Our Ref: LU/31/20/PL
Your Ref:

Town & Country Planning Act 1990 (as amended)
Town and Country Planning (Development Management Procedure) (England) Order 2015
Application for Planning Permission

Development Upgrade of football pitch floodlighting (resubmission following LU/299/19/PL).
Location Littlehampton Town Football Club The Sportsfield St Flora's Road Littlehampton

Title			Location Plan		
Scale		1:1250	At original	A4	© Robert Clark Associates Ltd
Drawing Number		2101/L1			Revision
					-

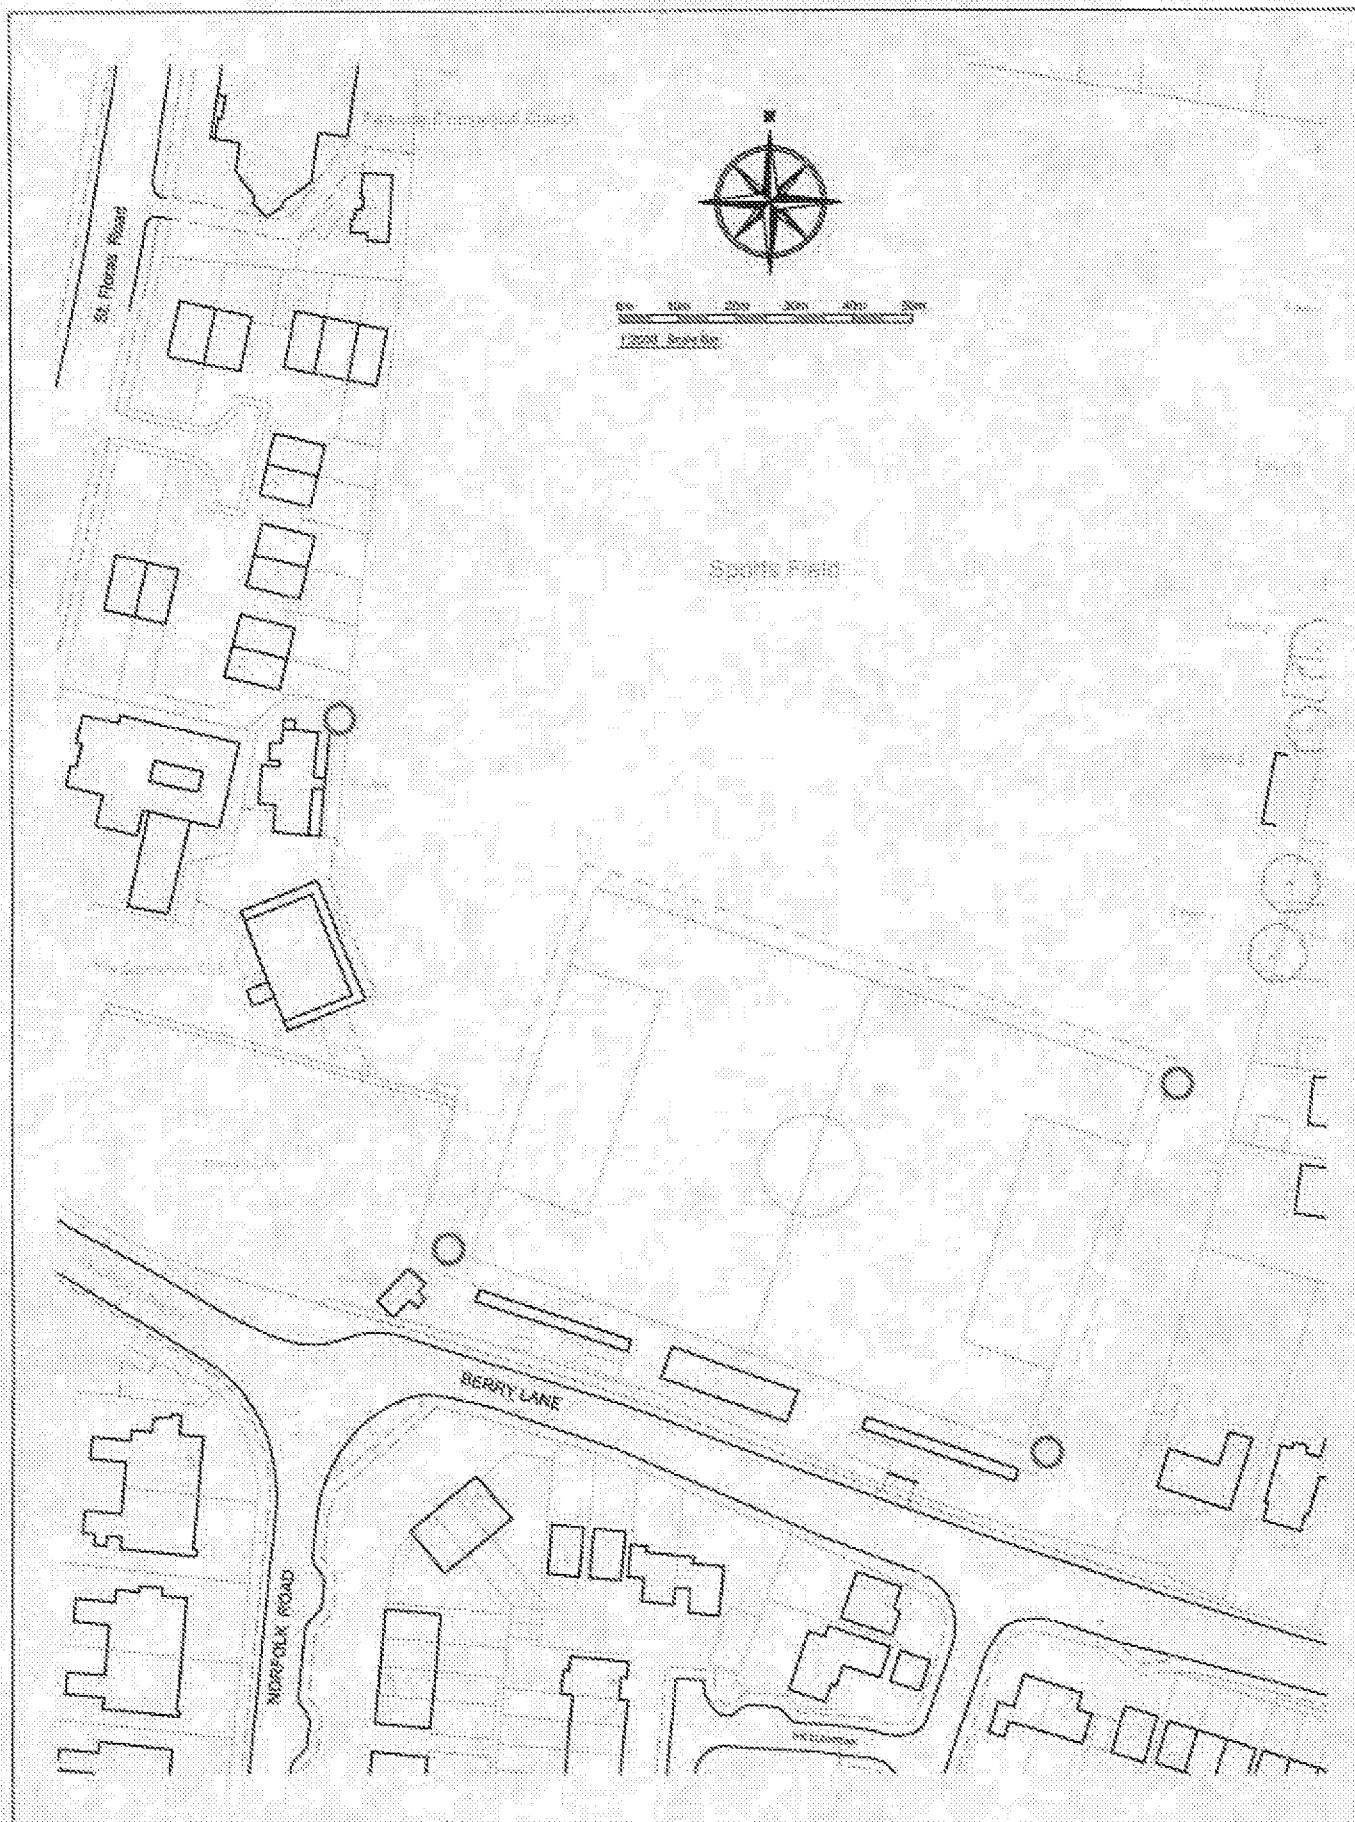
On the site plan, please highlight the position of the 4 No. lighting columns.
